**Re: Objection to MP08\_0244 MOD 1 Modification Request for Mixed Used Development at 23-37 Lindfield Avenue and 11 Havilah Lane, Lindfield**

As a resident of Lindfield, I/we wish to lodge an objection against the proposed Modification of the subject development based on the following grounds:

1 SHADOW DIAGRAM - 21stDEC_9AM
5003 SCALE1 : 650

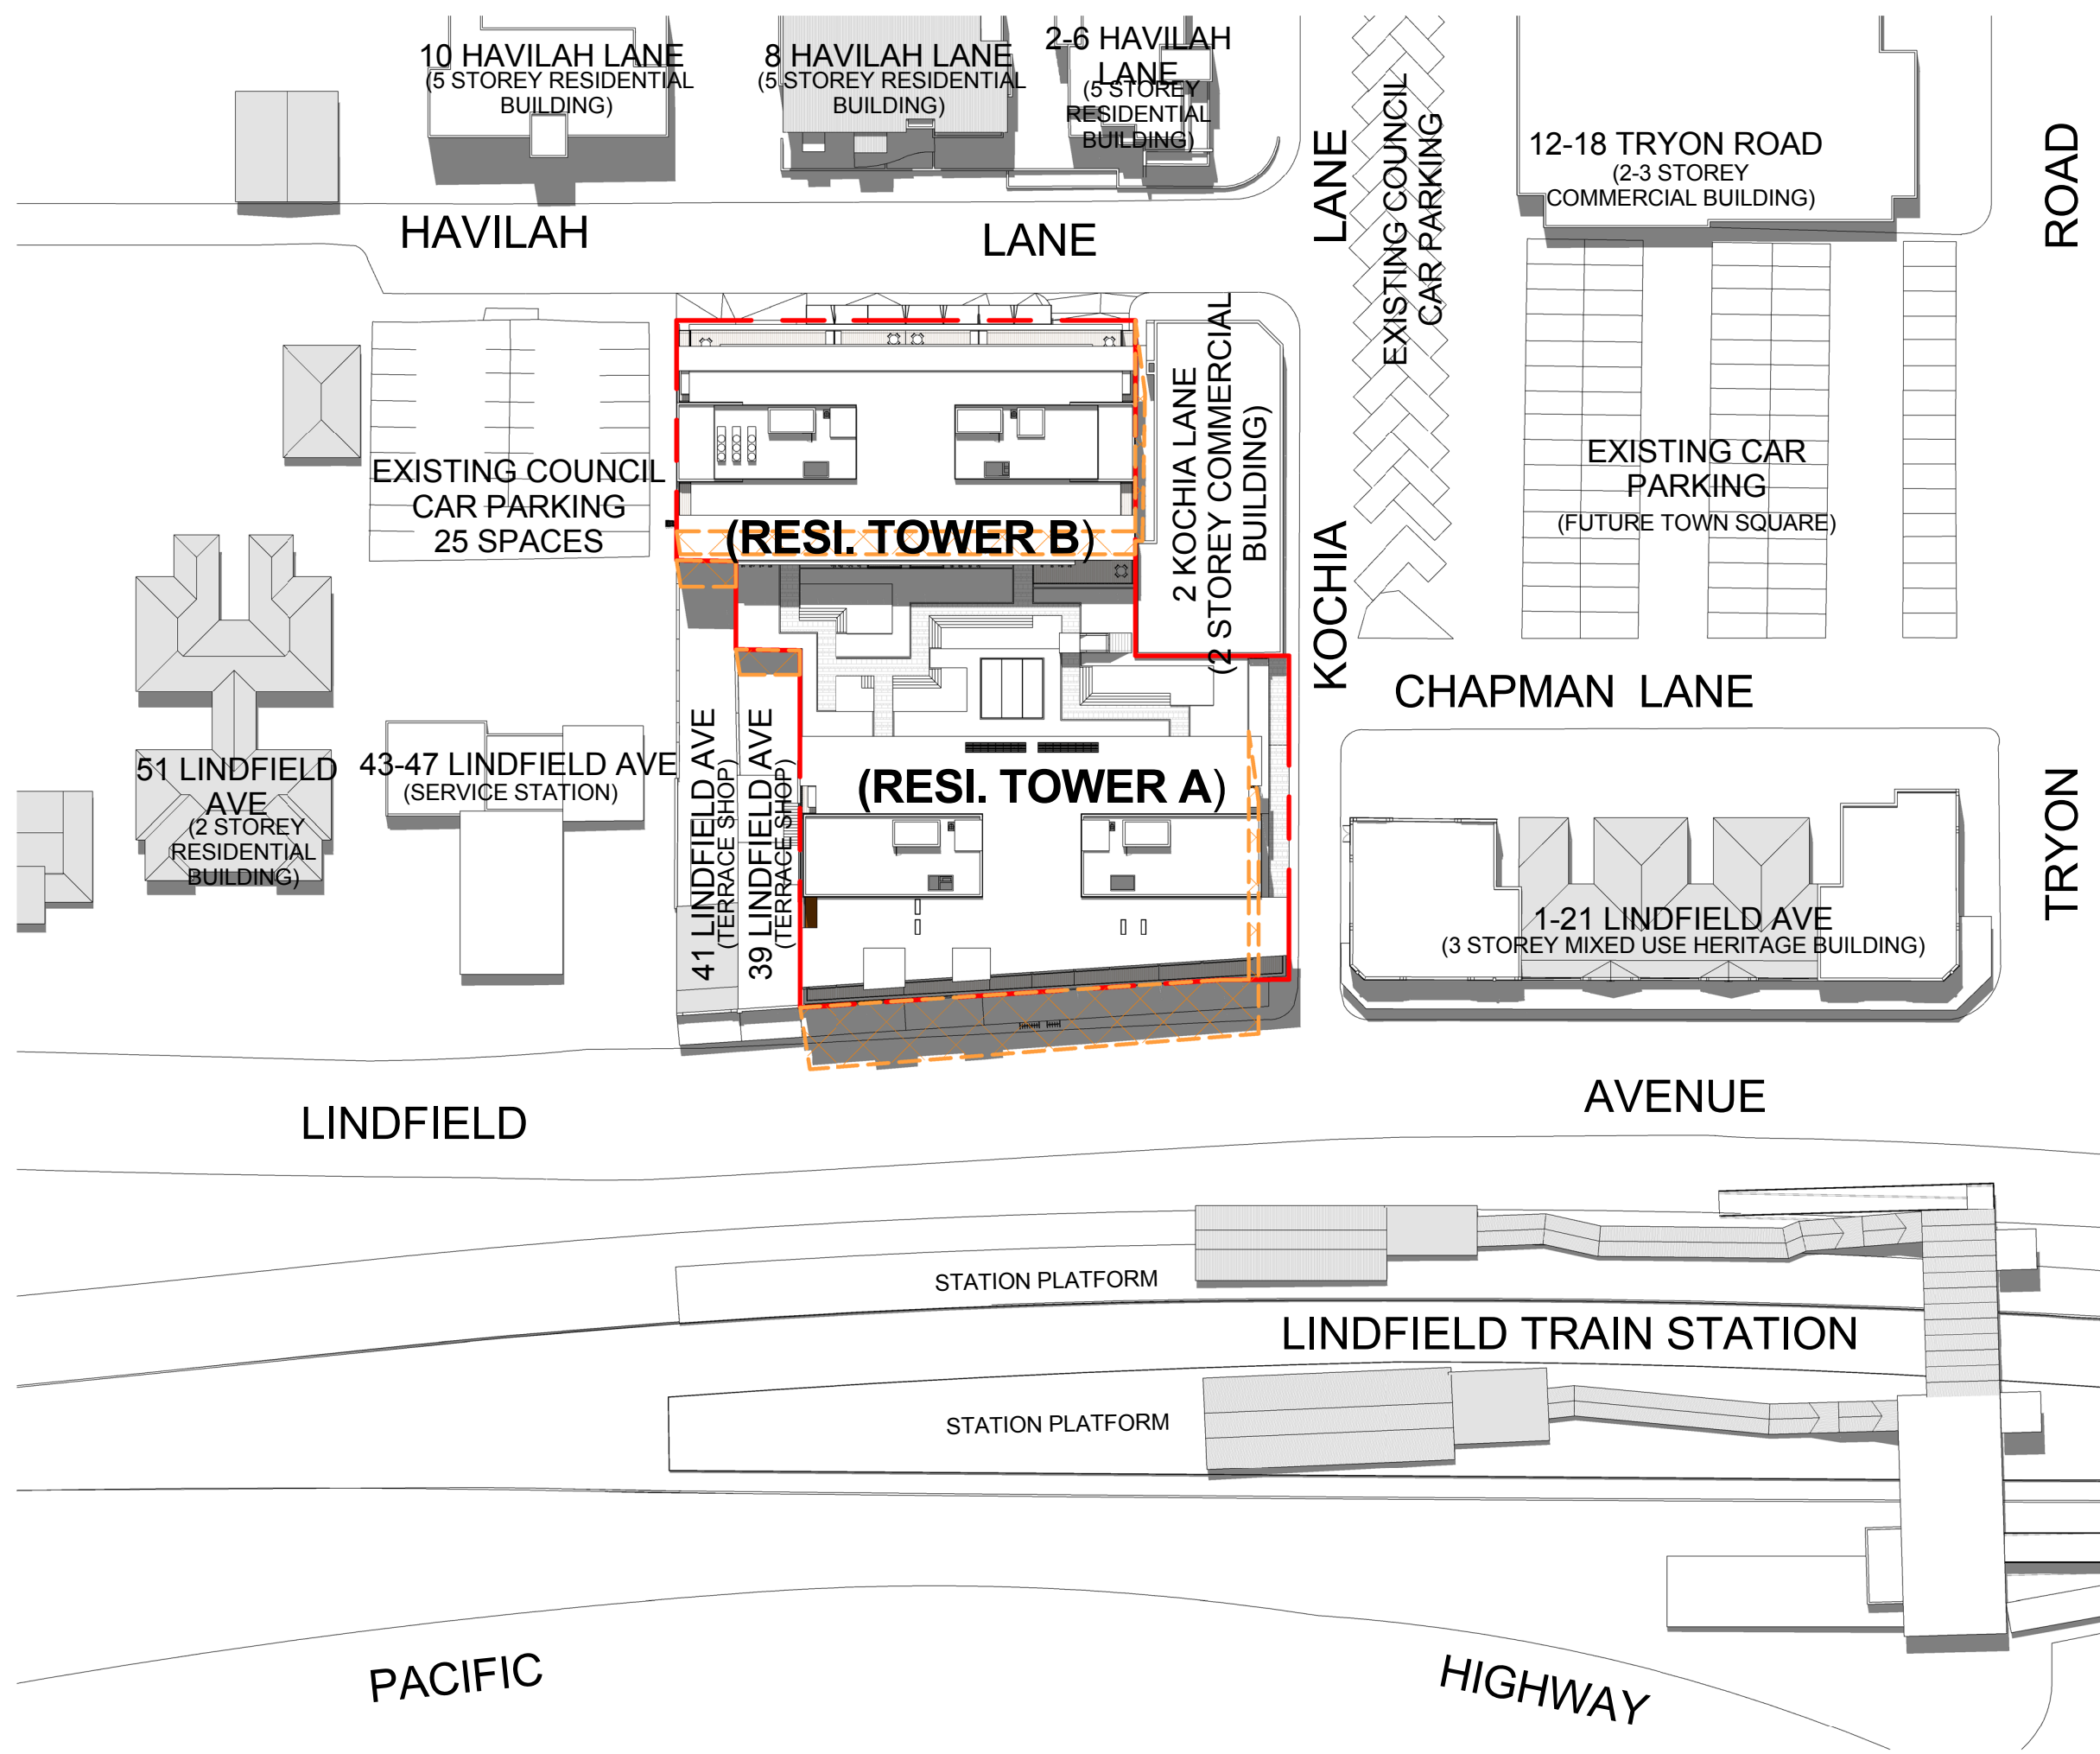
- The additional storeys create additional shadowing: particularly after 3pm for residents in the Havilah Lane apartments, and for all commuters on the city bound Lindfield rail platform, instead of 50% of the year, it will now be 75% of the year in the mornings.
